Office of Environment & Heritage

DOC17/313104-1
MP10-0137 MOD 8

Notification of Modification Application for Huntlee Residential Subdivision – Stage 1 subdivision and works, Branxton (MP10-0137 MOD 8)

Figure 5 Required APZ (PBP 2006)

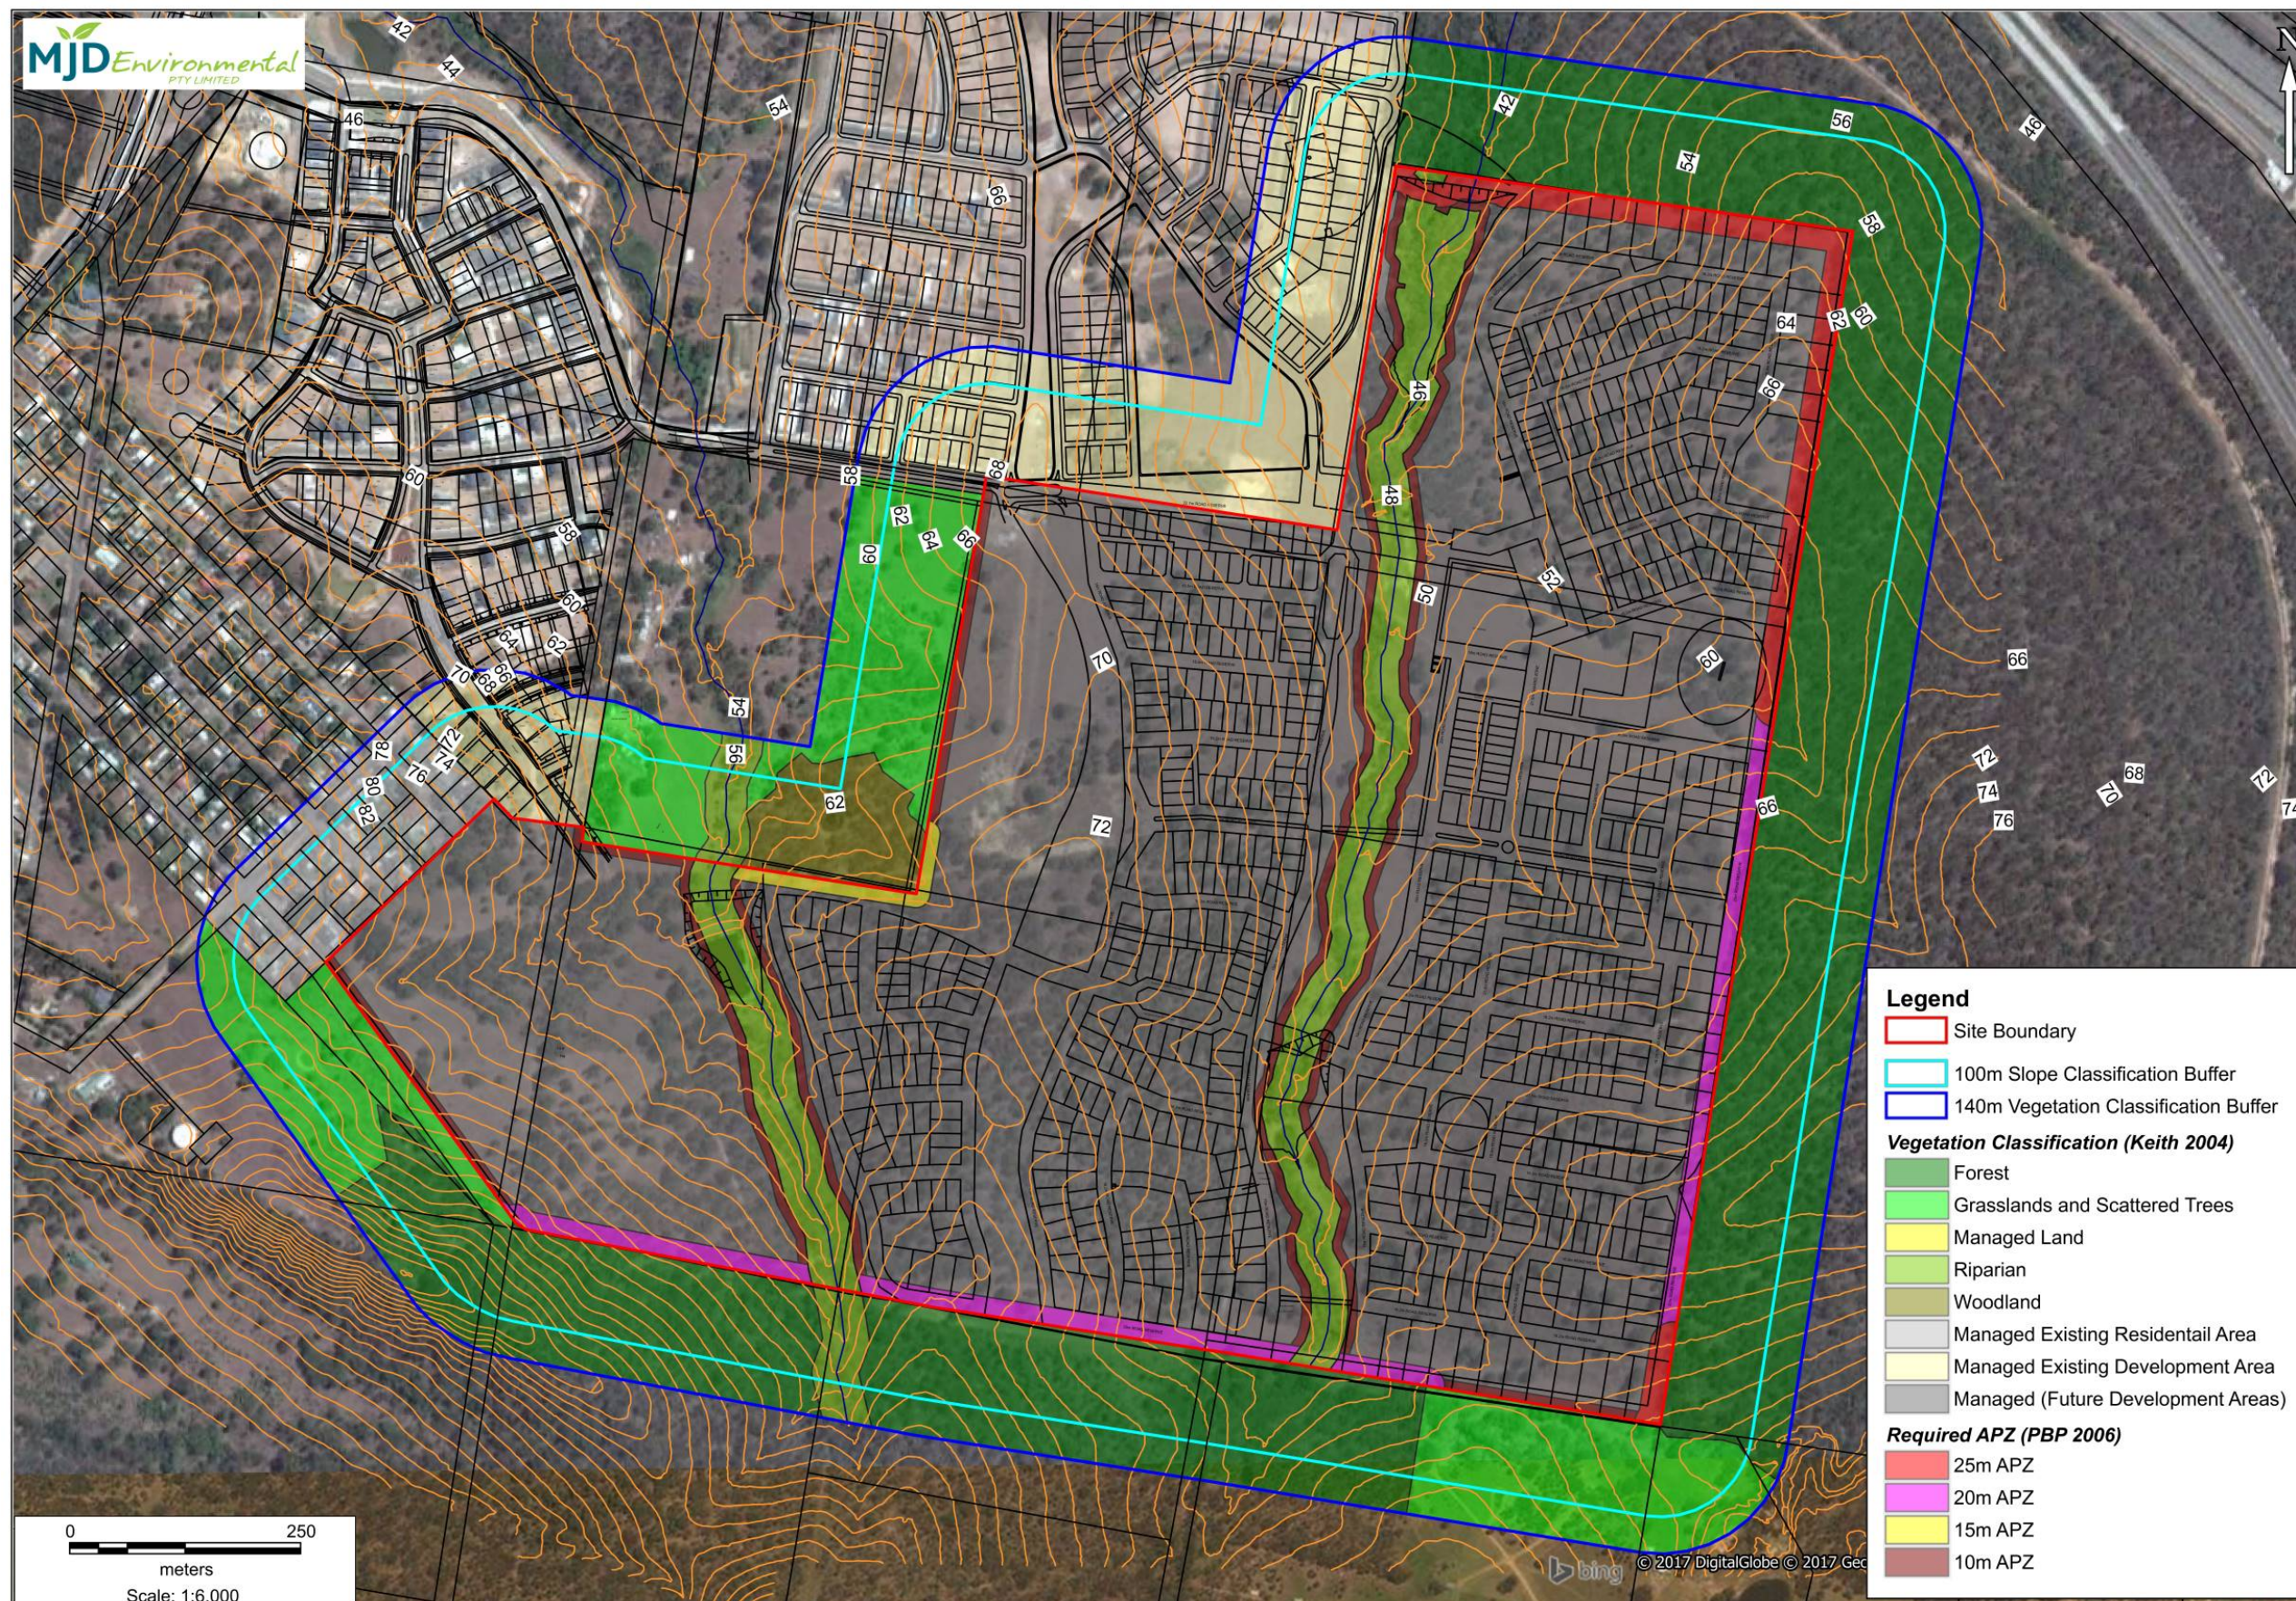
OEH seeks clarification on the location of the asset protection zones (APZ) as there appears to be contradiction between the documents provided. The Bushfire Threat Assessment for Modification 8 (dated April 2017) presents the APZs within the development boundaries (Figure 4, page 14). However, the cover letter to the Department of Planning and Environment (dated 26 May 2017) refers to the APZ as being outside the Stage 1 boundary on Page 3, and states that “... *this is a temporary APZ on land that will be subject to future development*”.

OEH does not support the location of APZs outside the development footprint, as impacts on biodiversity and Aboriginal cultural heritage have not been assessed for these areas.
